Please ask for: Mrs D Johnson
Email: daun.johnson@arun.gov.uk
Telephone: 01903 737762
Our Ref: M/109/21/PL
Your Ref:
Date: 2nd August 2021

Application for Planning Permission

Development: Erection of replacement dwelling. This site is in CIL Zone 4 and is CIL Liable as new dwelling.
Location: 188 Elmer Road Middleton-On-Sea PO22 6JA

Location Plan

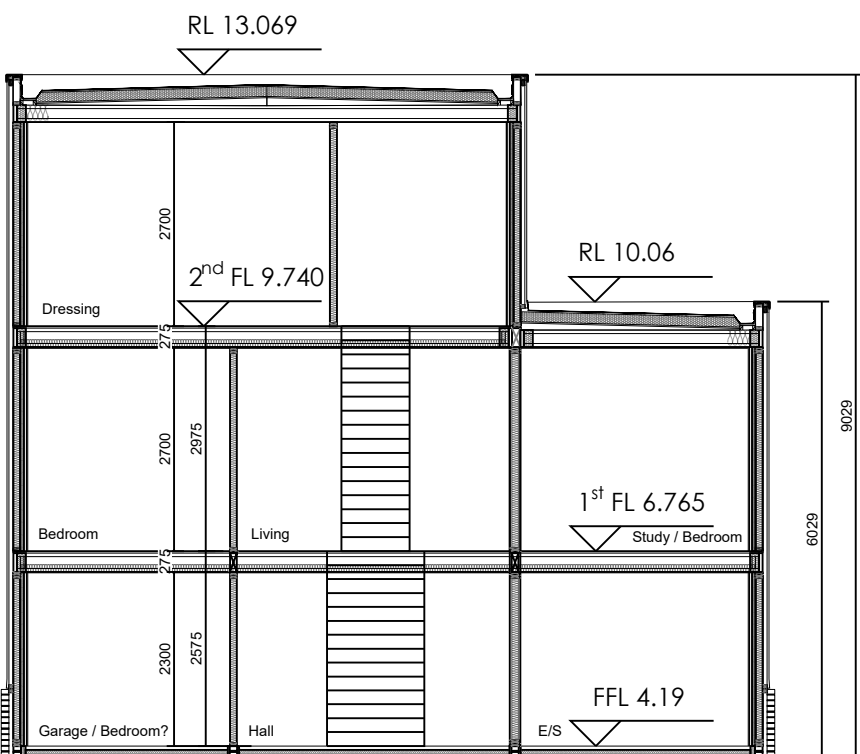
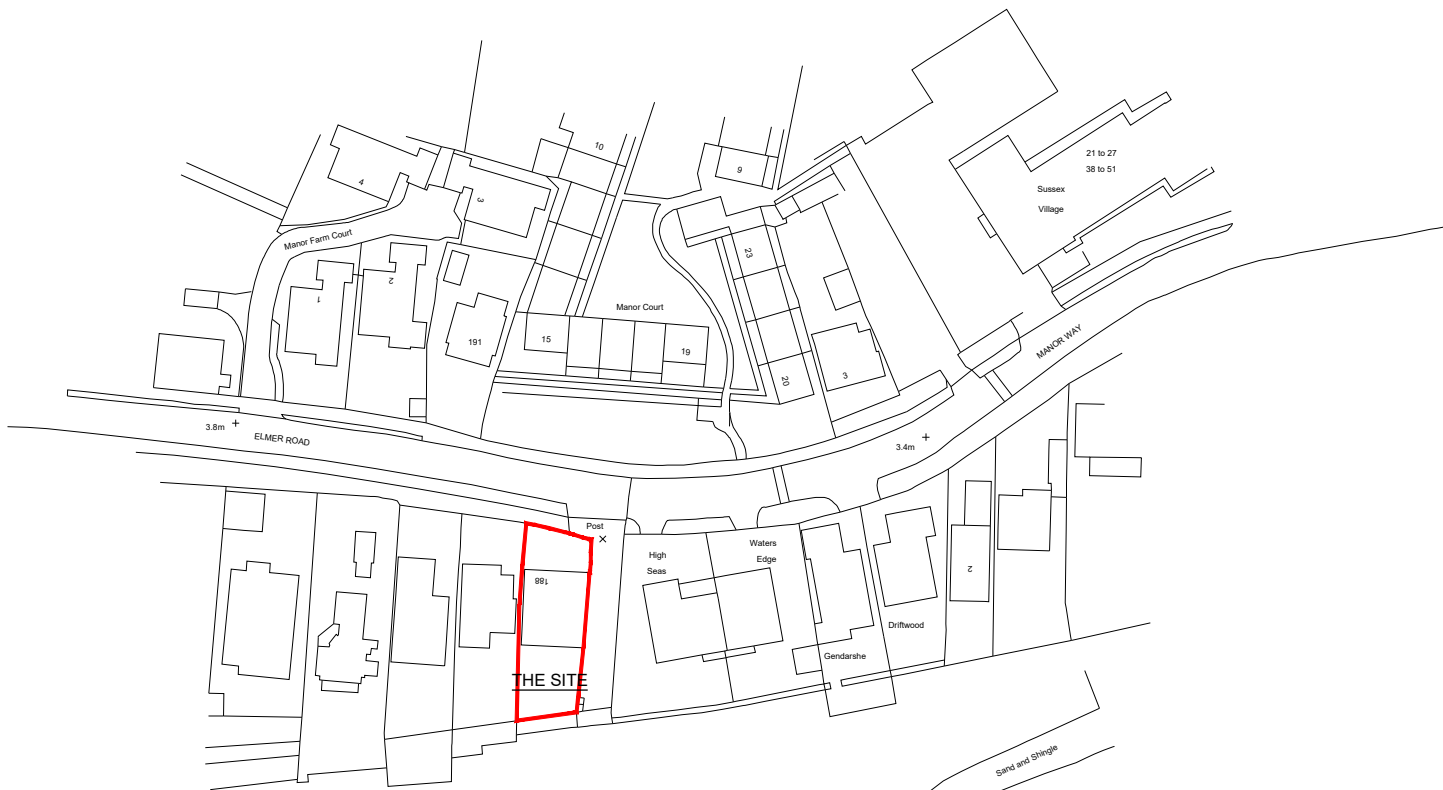
When comparing the location and block plans, it is not clear if the area south of the sea defence is owned by the applicant. If it is owned by the applicant, please include that area within the red edge on the location plan.
